DECISION DELEGATED TO DEVELOPMENT MANAGER

Application No: H19-0965-20 **Applicant:** Mr & Mrs C Fear
Proposal: Two Storey Extension to House
Location: Hollytree Farm Hall Gate Road Sutton St Edmund
Terminal Date: 23rd December 2020

Drawing.
PROPOSED
FLOOR PLANS - ELEVATIONS - SECTIONS

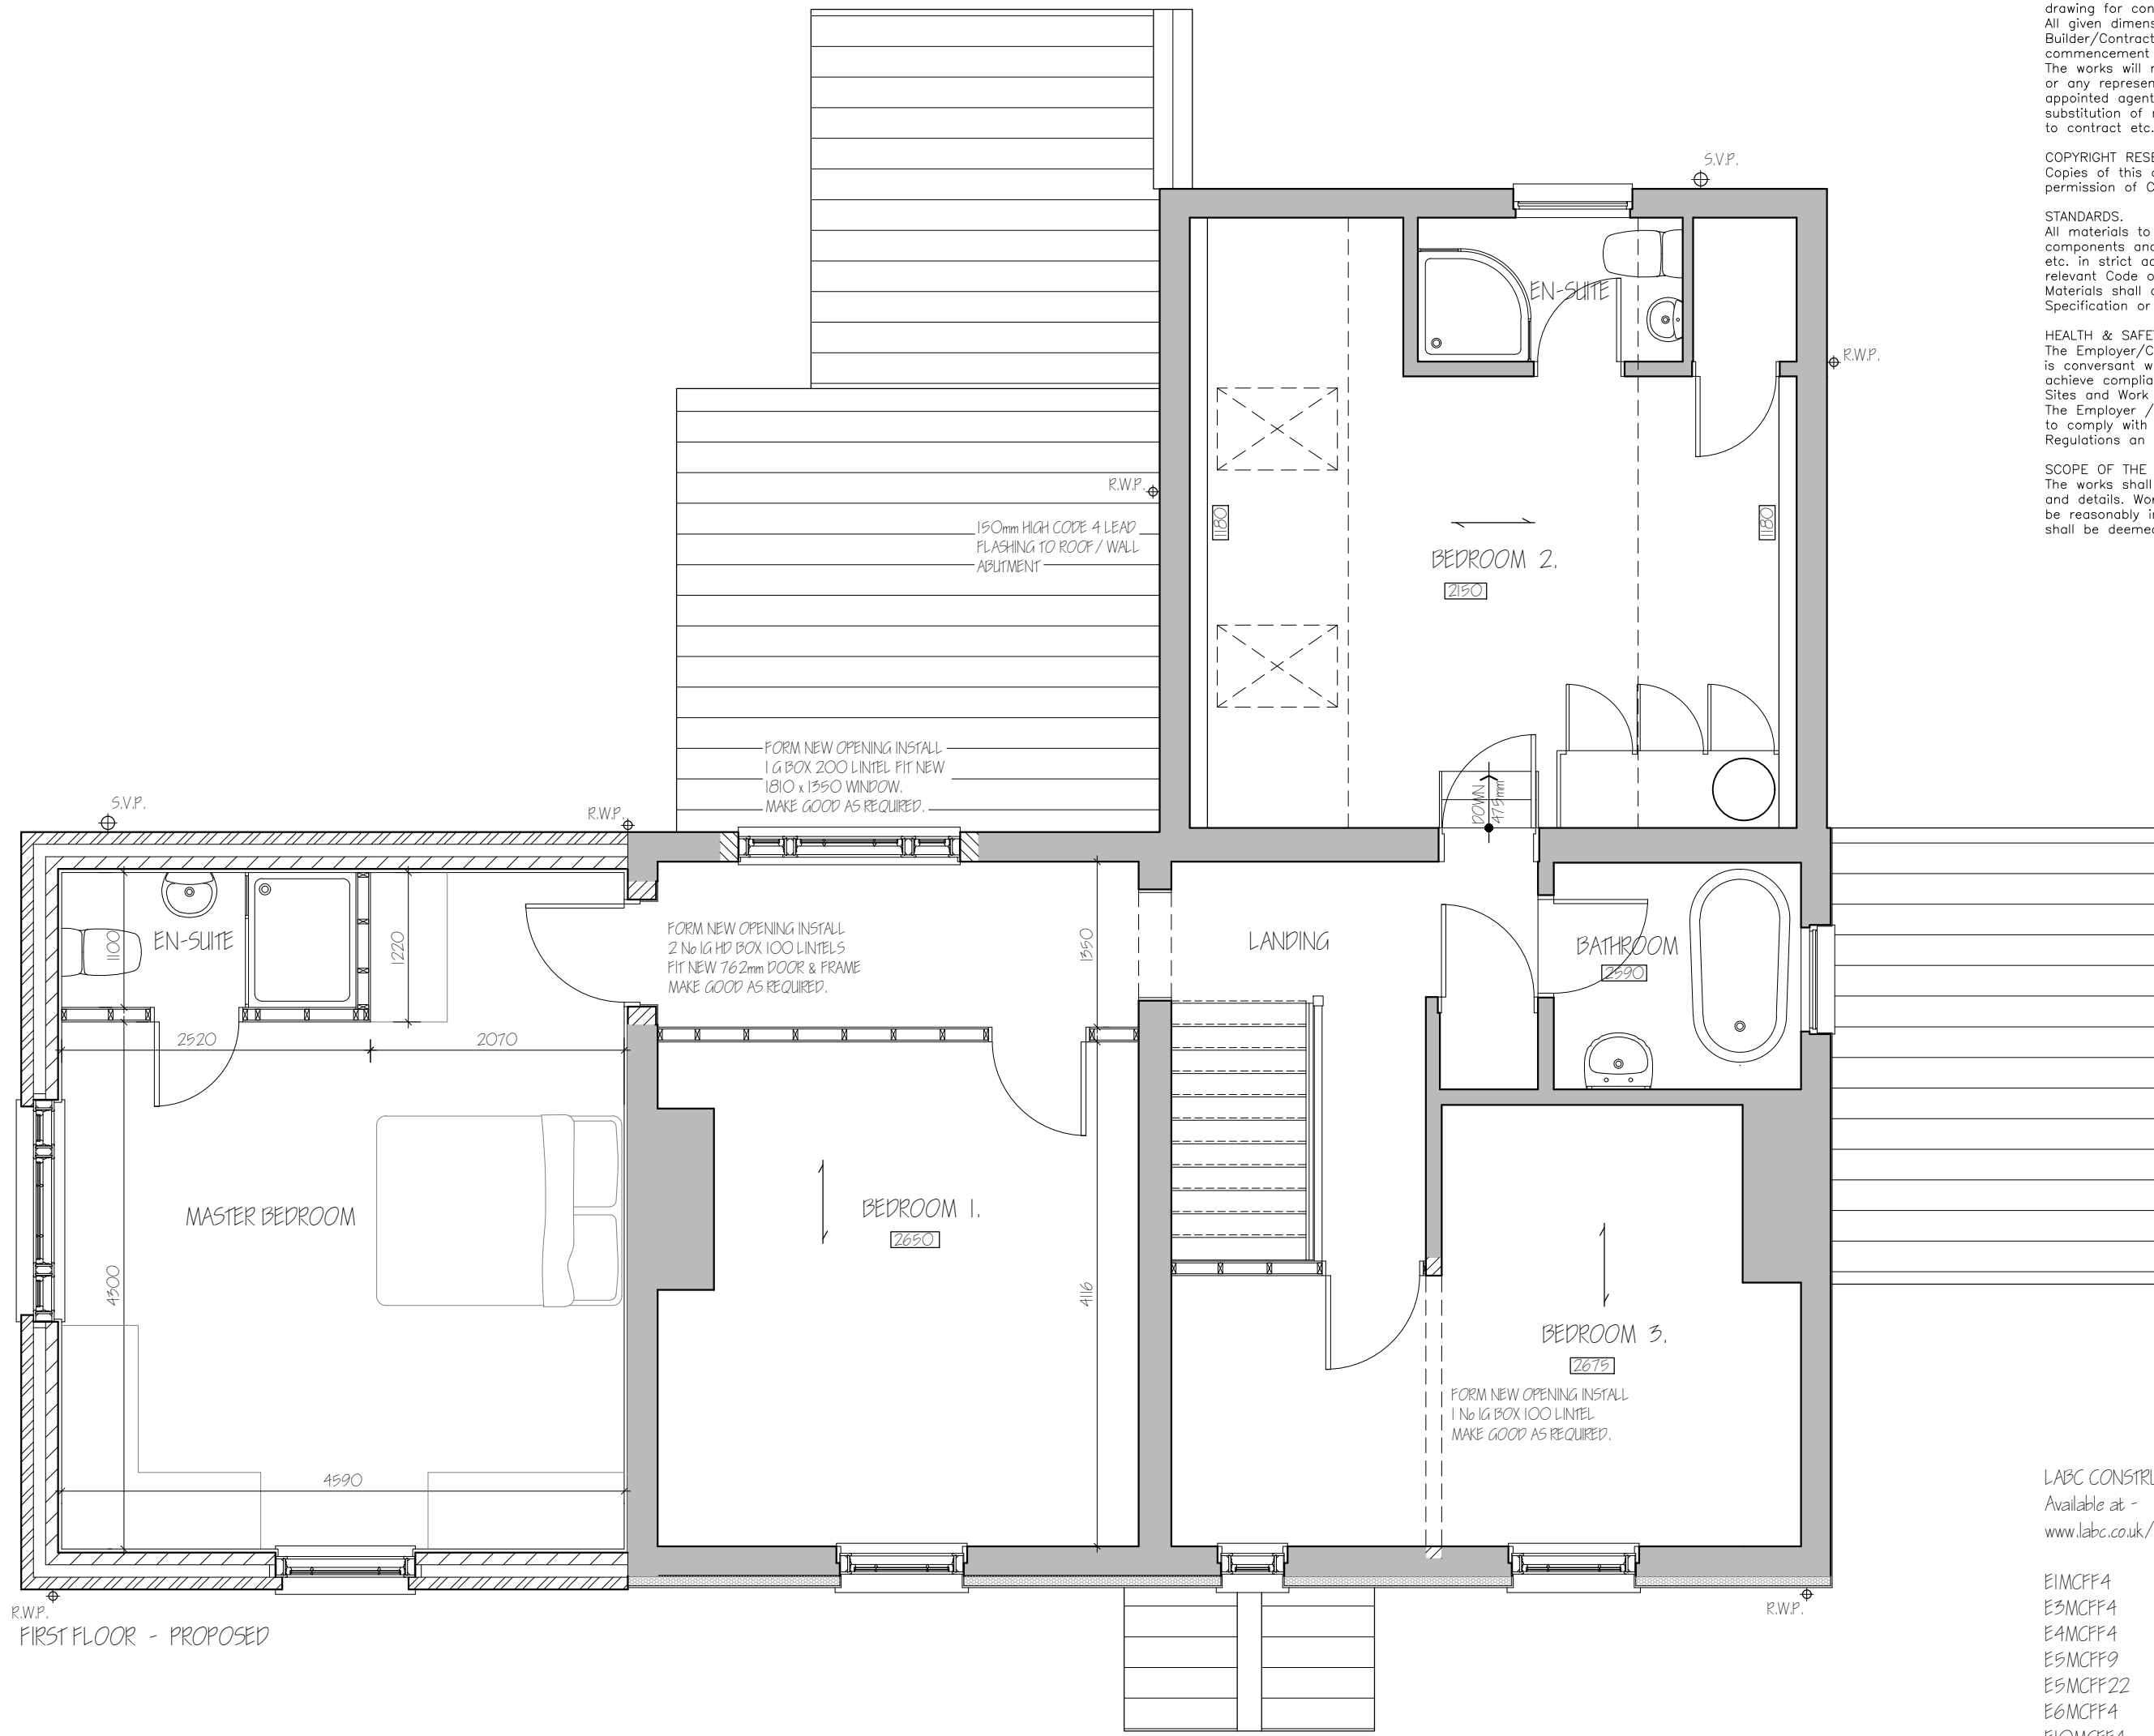
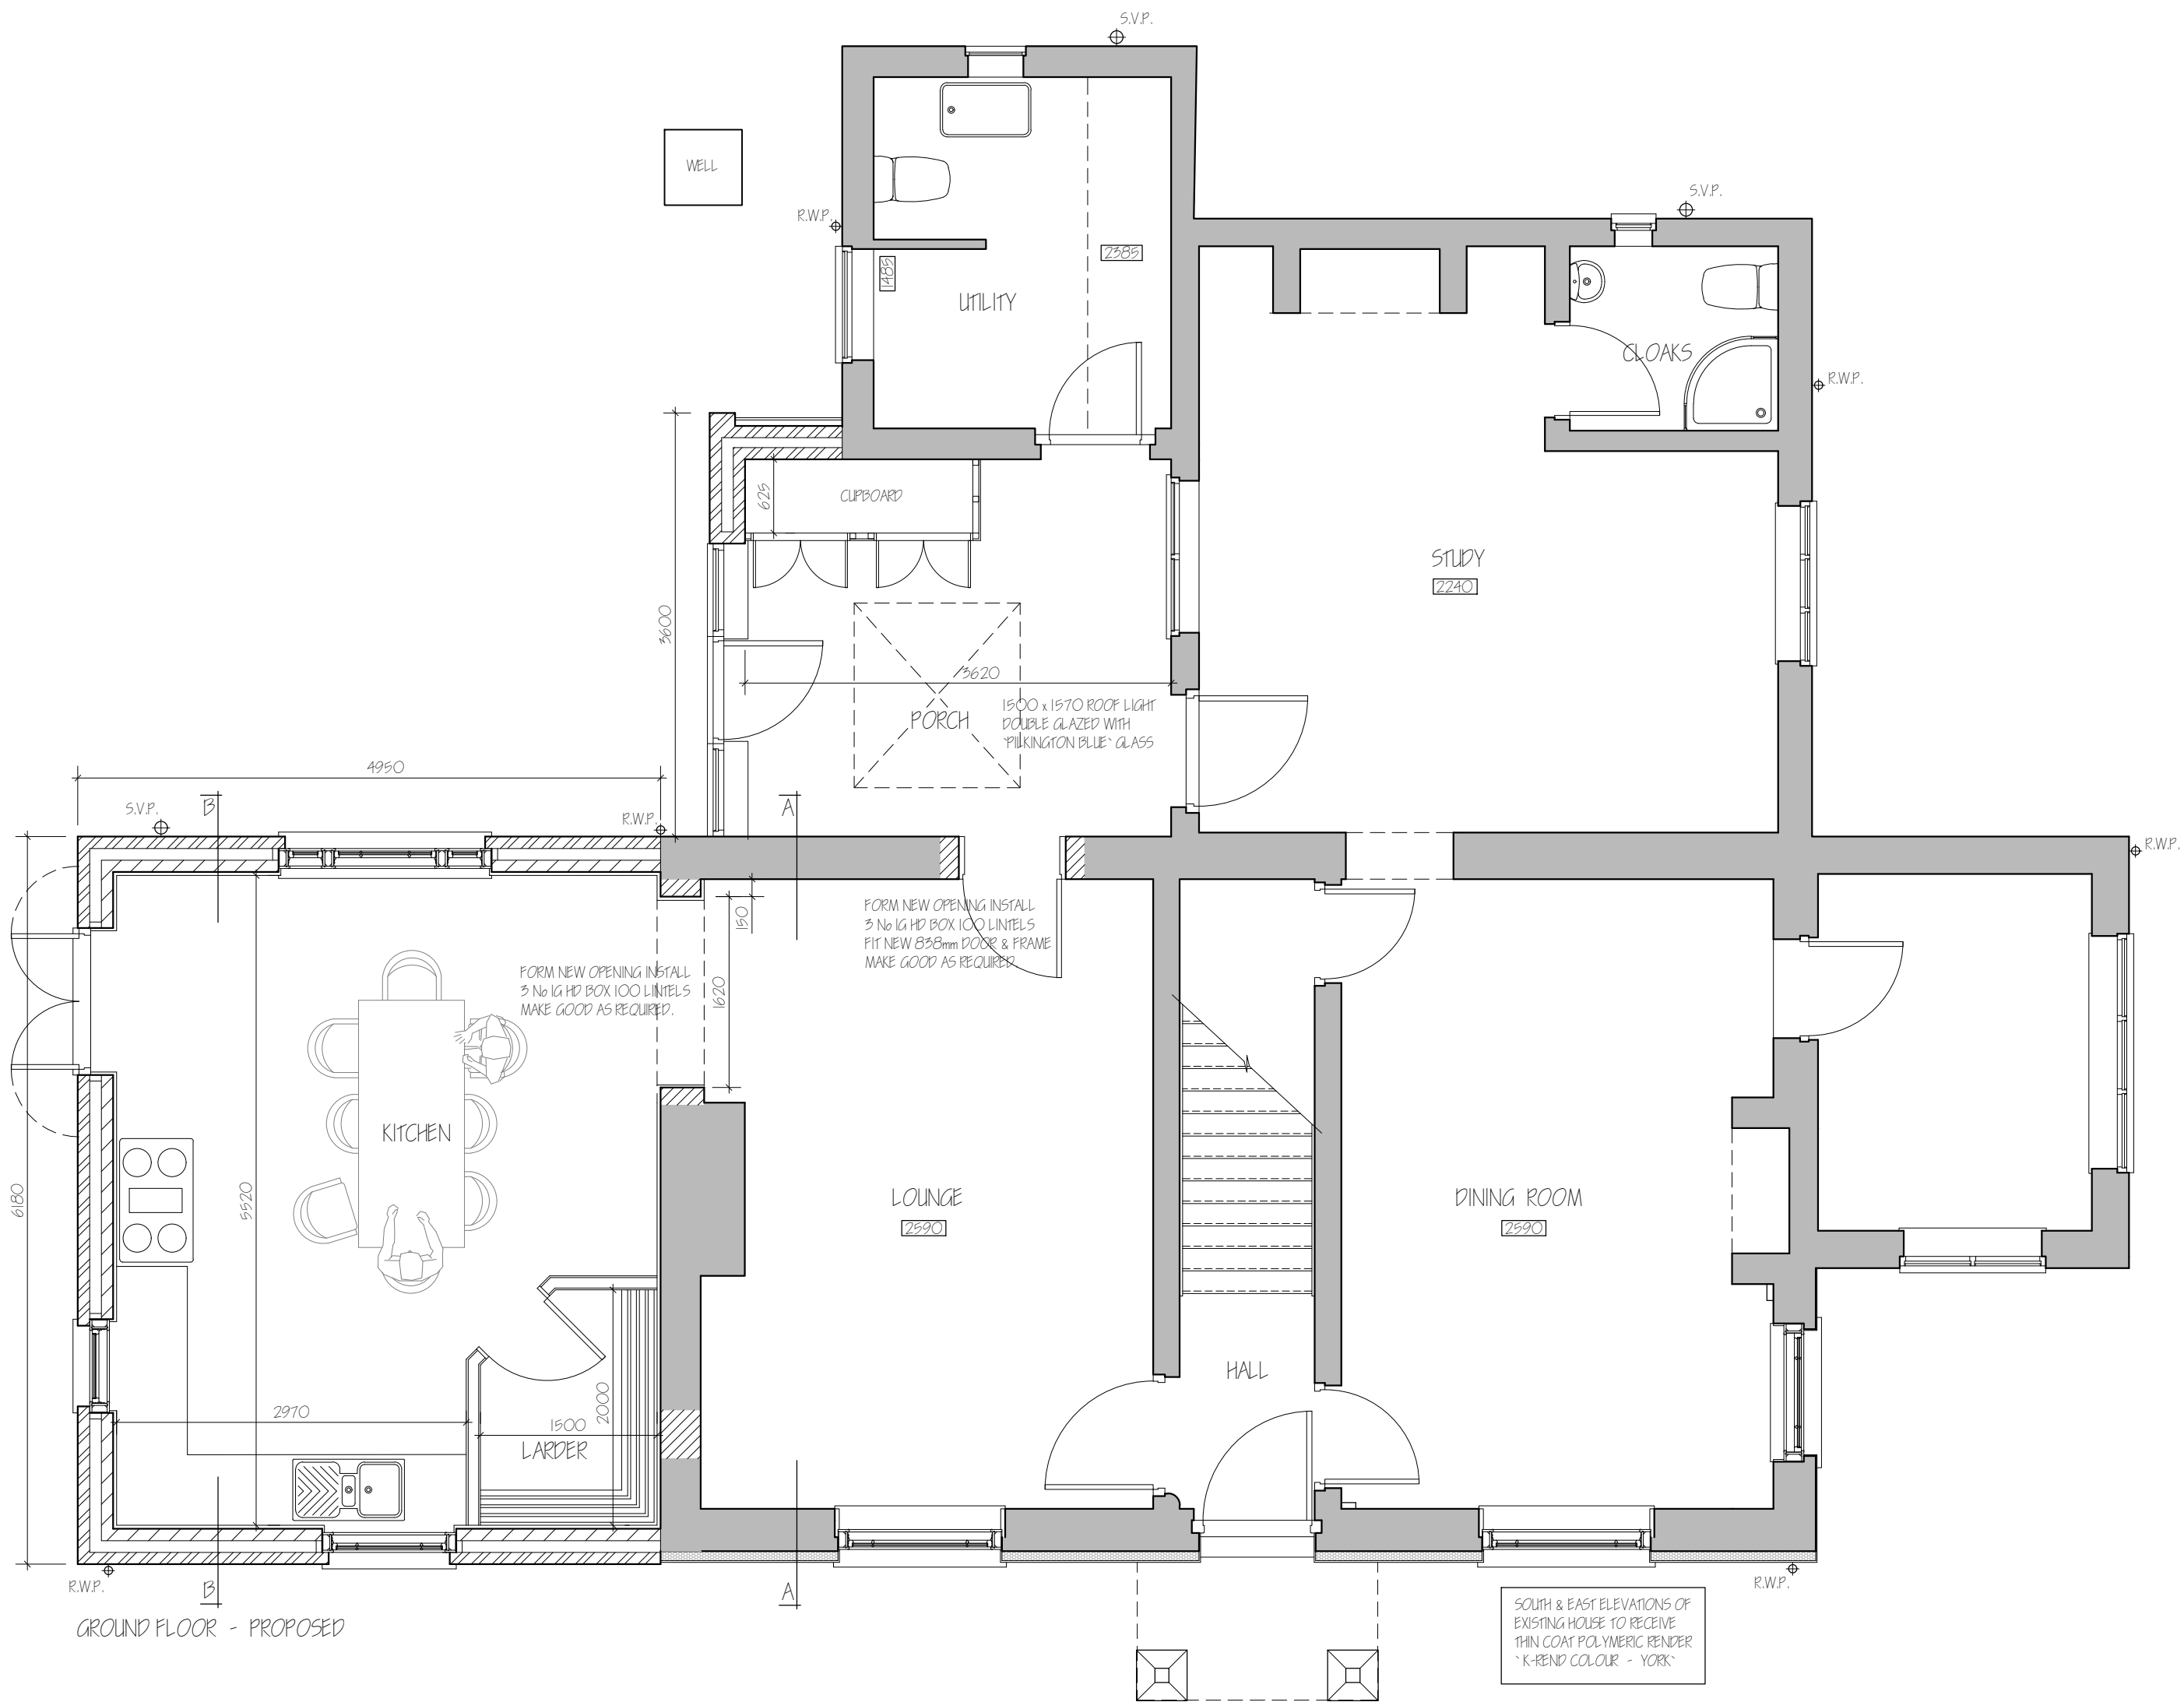
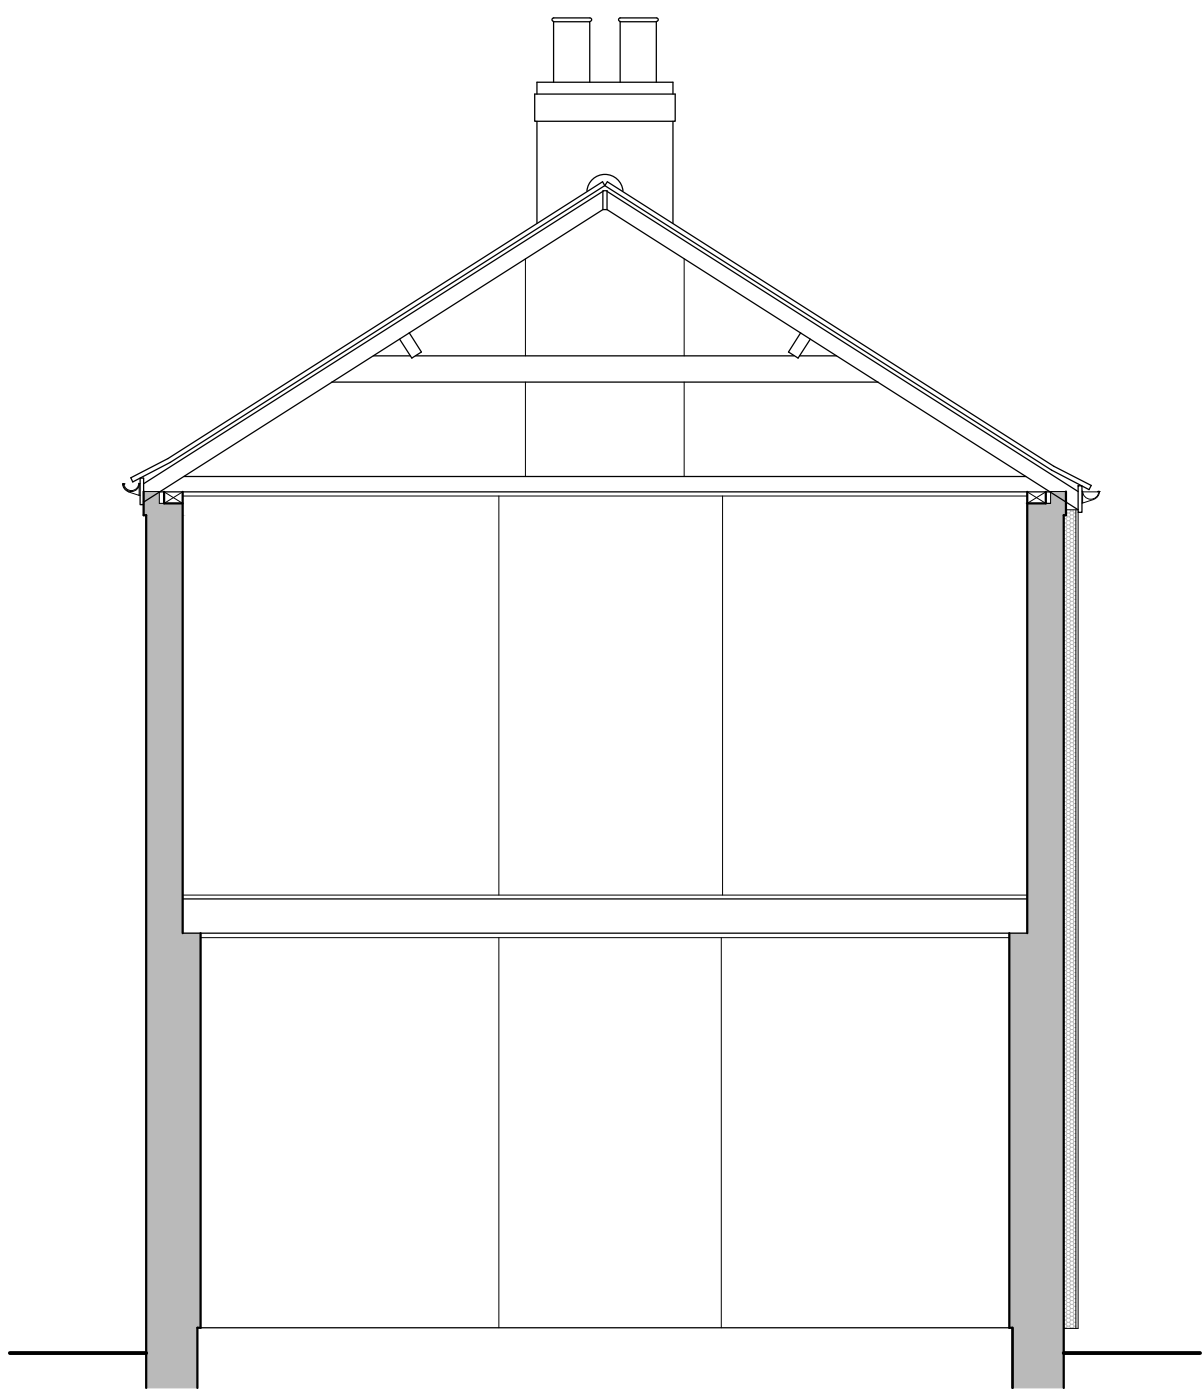
The proposed two-storey extension will protrude 4.95 metres from the western side wall. The depth will be as much as the gable wall. Its apex height will be 7.50 metres which is 20 centimetres below the ridgeline of the house. The porch at the rear elevation will be marginally widened. Having also regard to the dimensions of the house, it is concluded that the proposals will be subservient to the host property in terms of scale, mass and bulk.

A gable pitched roof will be formed tantamount to the existing roof of the dwellinghouse. Stone lintels and sills as well as brick detailing off the fascia will be replicated in the extension matching

the existing features of the house fabric. All elevations of the proposed extension will be facing brickwork. Render will be applied on the southern (front) and eastern (side) elevation of the original house. Despite the new material of render, the proposed design and layout of the proposals will be still congruous with the original fabric of the house.

Internally, the proposed development will gain further floorspace for a new kitchen on the ground floor level and one ensuite master bedroom on the first-floor level. The existing kitchen will be replaced for a study room. The purpose of the development will meet the householder living needs and in keeping with the residential use of the building.

The barn to the south of the dwellinghouse is awaiting permission for conversion into single dwelling. Should permission be granted, no significant overlooking effect will occur between the front windows of the extension and those in the new dwelling. The separation distances will be in the region of 15 metres and there will be no first-floor windows other than roof lights for non-habitable loft space.

The additional bedroom proposed would increase the total number of bedrooms from 3 to 4. Three spaces for dwellings with 4 or more bedrooms should be provided within the curtilage. The drive area is visibly spacious to accommodate three cars.
